RE: Scottish Hospital Proposal, Paddington NSW

Ref # MP09_0016

Date : 15/12/10

Tree protection zones

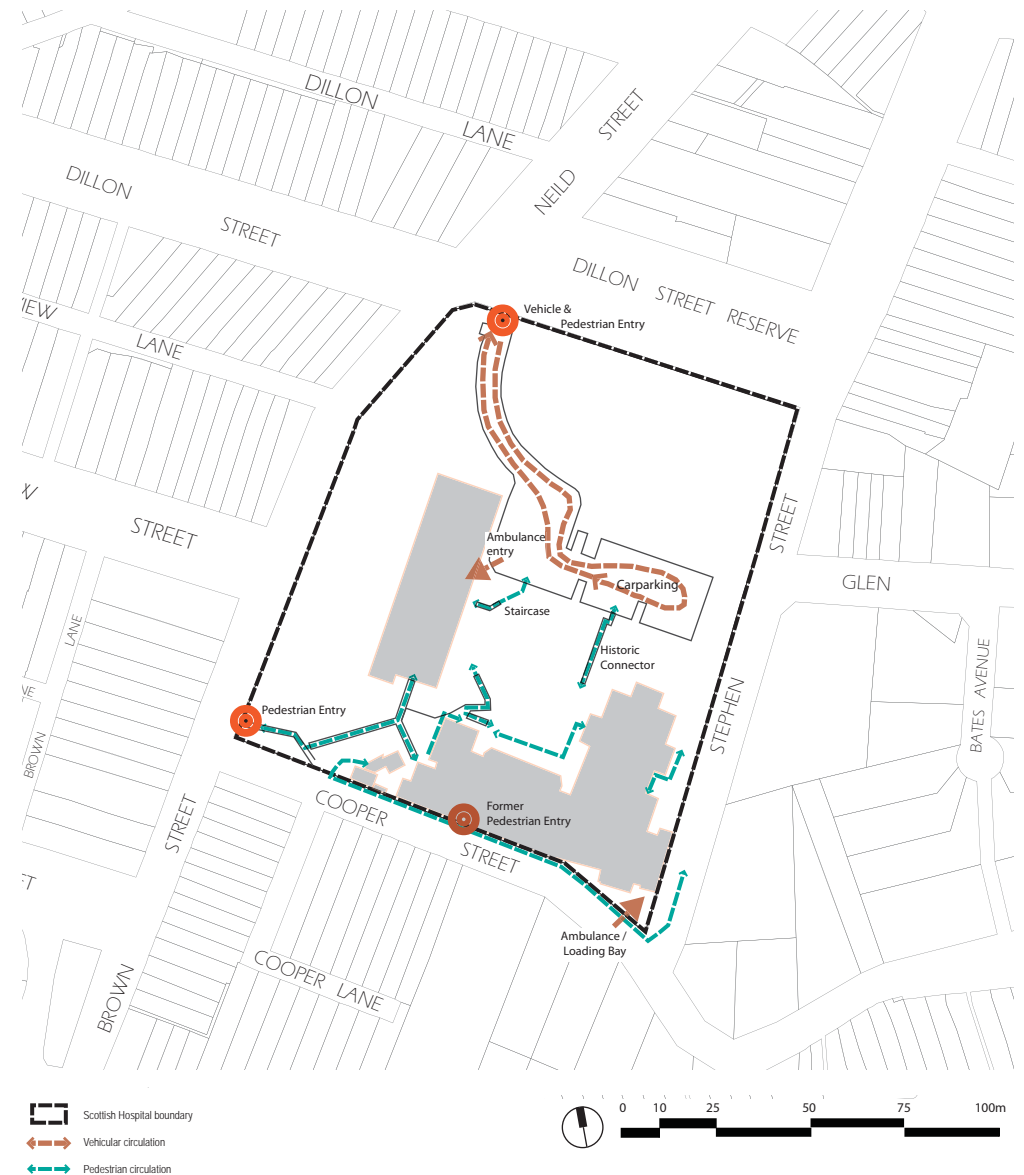
1. All trees along Stephen St are slated to be removed, with the exception of two trees at the far north-east corner. The Abourist report classified nine trees along the boundary of Stephen Street as Retention Value B 'Could be retained'. Most are Chinese Hackberry, Camphor Laurel and Coral Trees over 10 metres tall, which are protected under Woollahra Council Tree Preservation Order (TPO). Elsewhere on the site these same species have been retained. There is no justification for the removal of the trees along Stephen St. T37 (19 metre tall Camphor Laurel), T35 (mature Brushbox) and T 31 are of particular value to our building at 40 Stephen St.

We request that the mature trees along Stephen St, and particularly the Retention Value B trees, be retained and protected.

STEPHEN STREET ELEVATION

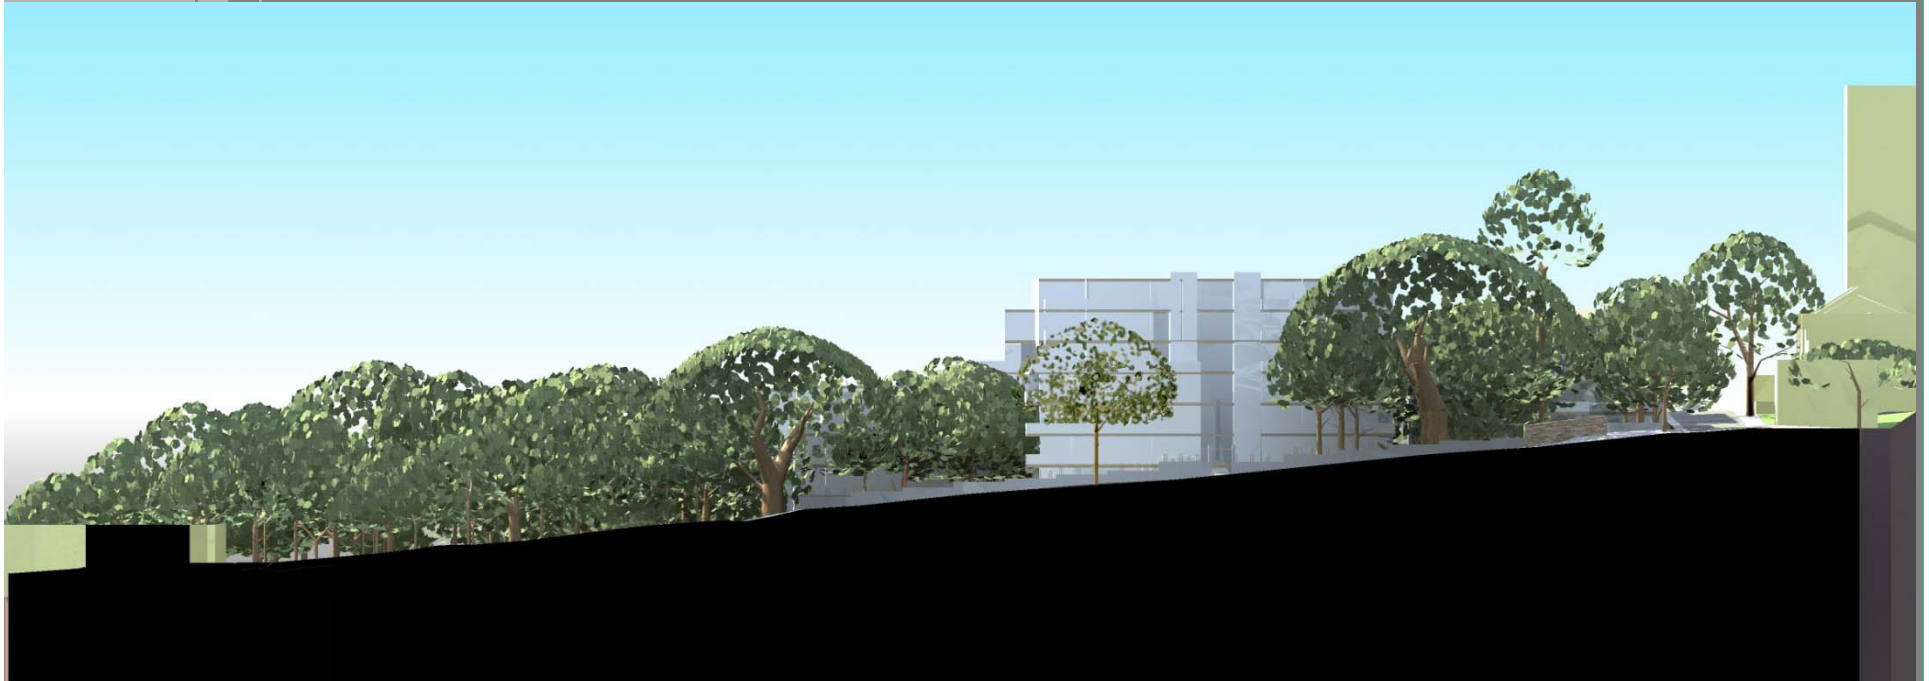
3. The boundary setback for the RACF varies from as little as 3.2 metres up to 6.2 metres. Vegetation will be further reduced when egress for fire stairs is included, and if footpath widening is approved subject to a Voluntary Planning Agreement (VPA) proposal with Woollahra Council.

The measured distance from 40 Stephen St living room and kitchen windows to the RACF balconies is as little as 16 metres. These setbacks:

- a) do not allow for significant trees to be retained or replaced
- b) do not meet the required SEPP 65 separation distance of 18 metres for buildings of this size.

We request that the RACF and ILU building setbacks be increased to allow significant trees to be retained, and to meet SEPP 65 separation requirements.
